Ribble Valley Borough Council
By email

Your ref: 3/2024/0389
Our ref: DC/24/1413
Date: 18-JUN-24

Location: Land at the North of the Chapel Hill site Longridge
Proposal: Approval of details reserved by conditions 14 (surface water drainage strategy)

PROPOSED SURFACE WATER DRAINAGE LAYOUT

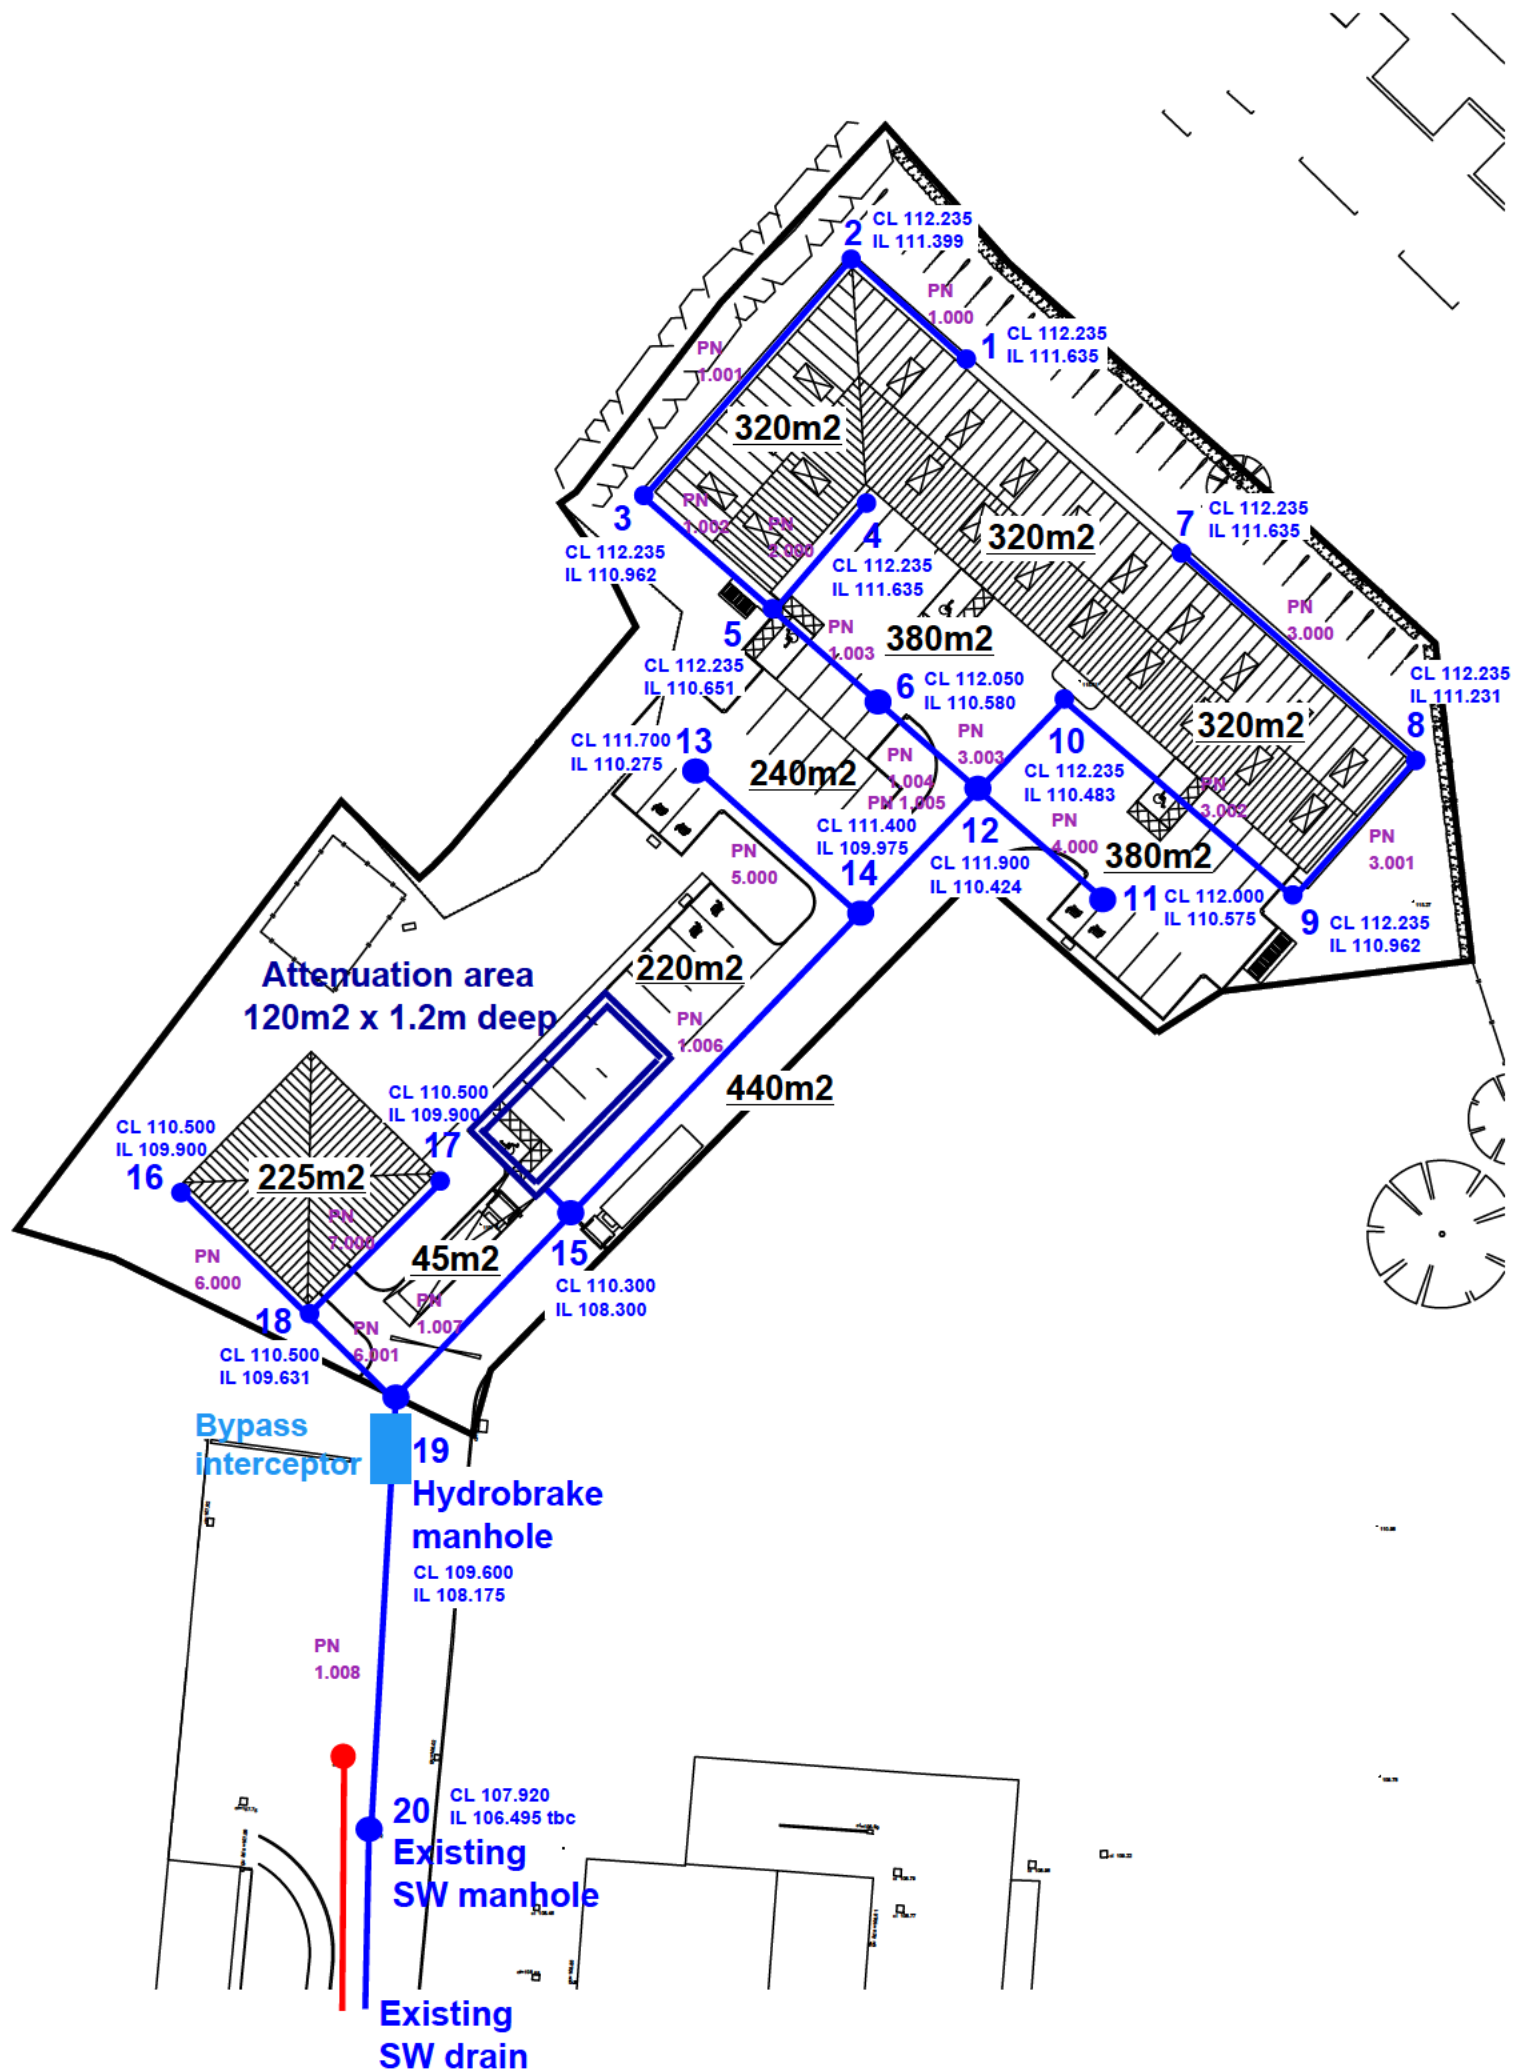
Further to our review of the submitted drainage strategy prepared by REFORD, dated April 2024, United Utilities has no objection to condition 14 being discharged. We would request on site infiltration testing be undertaken to prove infiltration via soakaway is not feasible. We would request that the survey of the existing drainage is submitted, and proof that upstream sites are also drainage surface water to what is recorded as a dedicated foul sewer within Chapel Hill.
